From: Martyn White
Sent: 23 November 2018 17:21
To: Stuart Corbey
Cc: Planning.Responses
Subject: LU/182/18/PL

LU/182/18/PL

The proposal is for the demolition of the existing structure and its replacement by a much larger development. The existing street facing building is single storey and reflects some of the main characteristics of the neighbouring flint building; a small scale, simply constructed structure.

Proposed street elevation (west) to Pier Road Scale 1:100 @A3

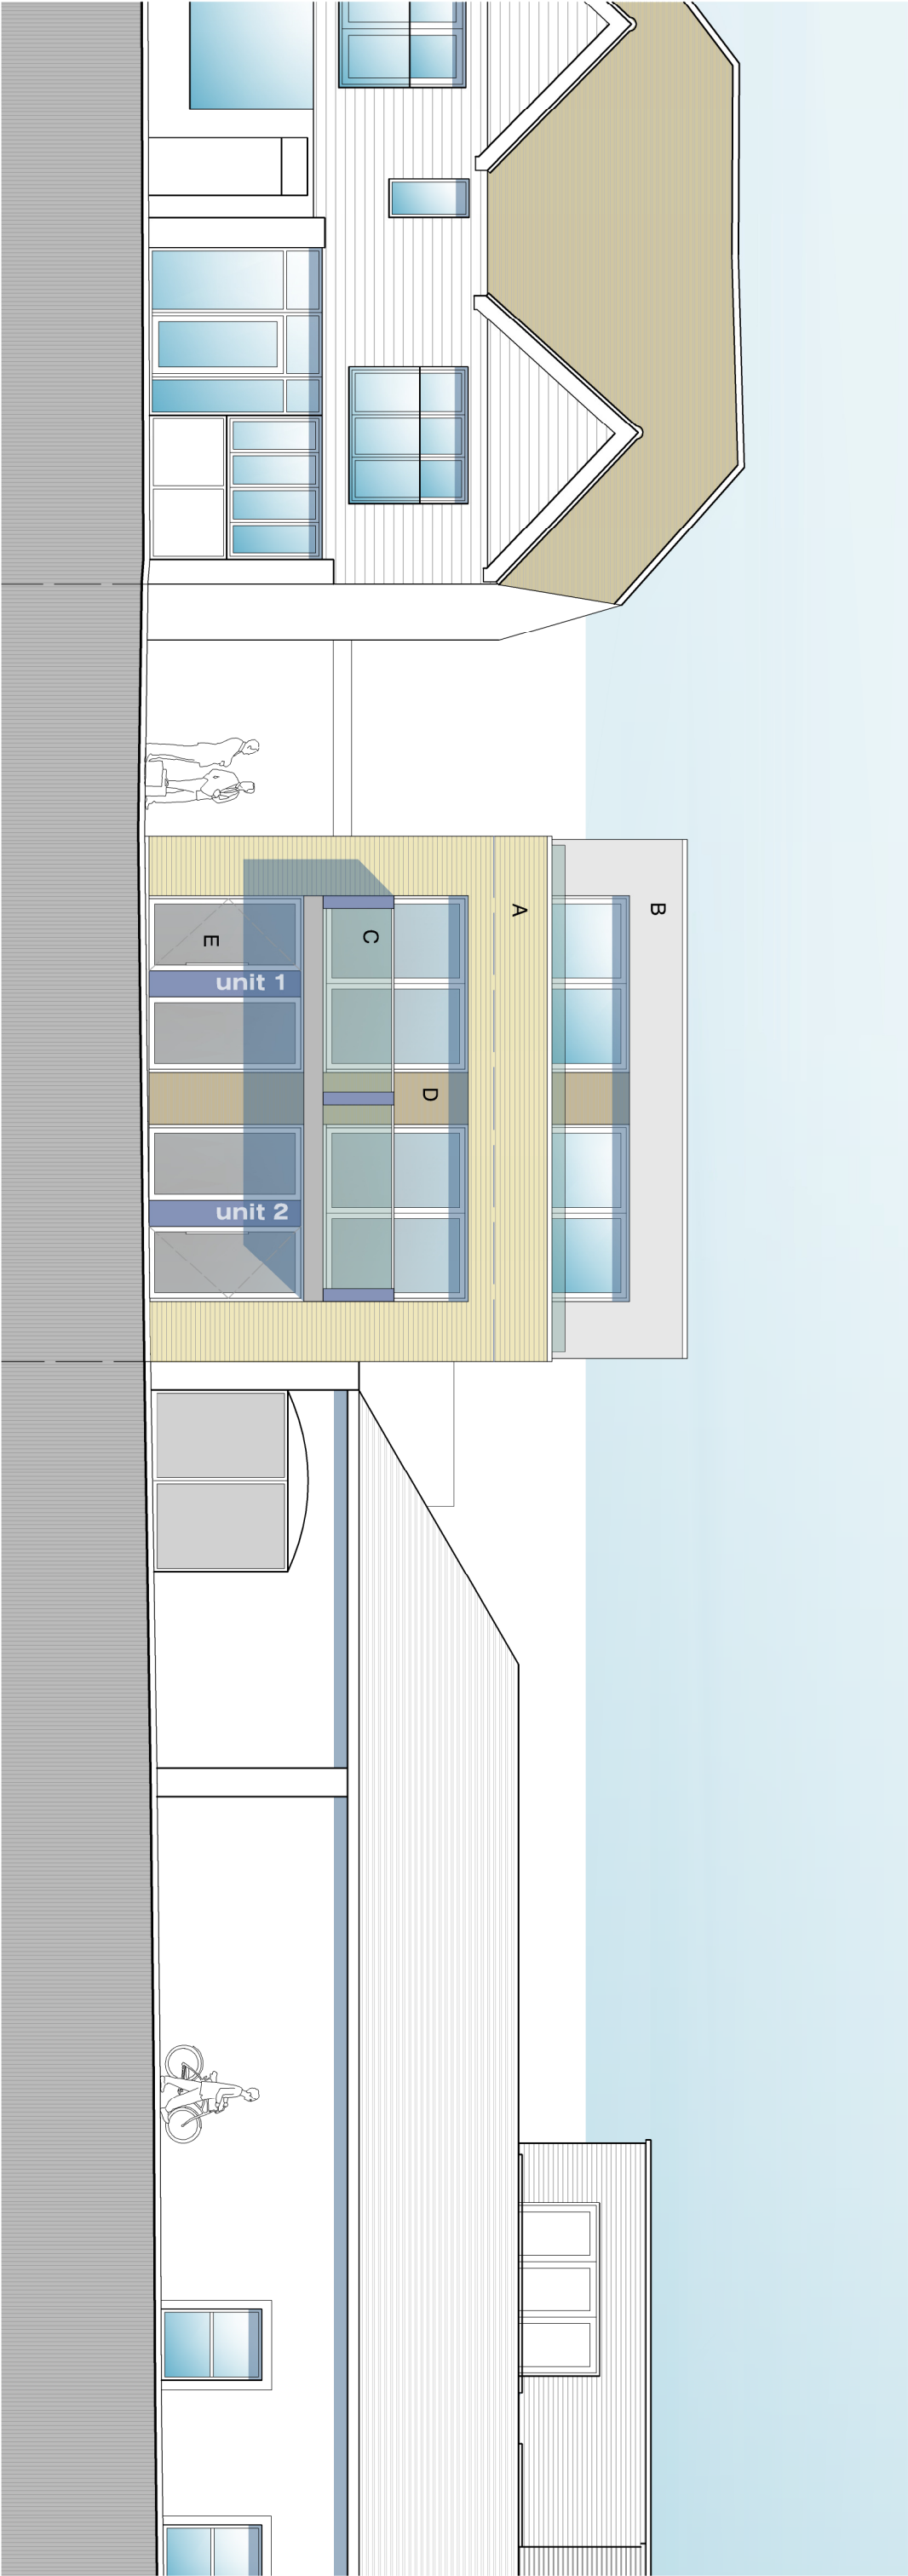
Many of the nearby or neighbouring buildings have been identified as Buildings or Structures of Character, and are therefore heritage assets for the purposes of the NPPF. The most notable building is the drill hall which immediately adjoins the site, and plays a significant role the street-scene. Development in this location should consider the impact upon this building.

The proposed building is substantially different from the existing structure in terms of appearance and height. There appears to be an excessive amount of glazing present, which is not necessarily characteristic of the area. As a consequence, it is considered that it would appear dominant on the street-scene, and would affect the setting of the cadet building.
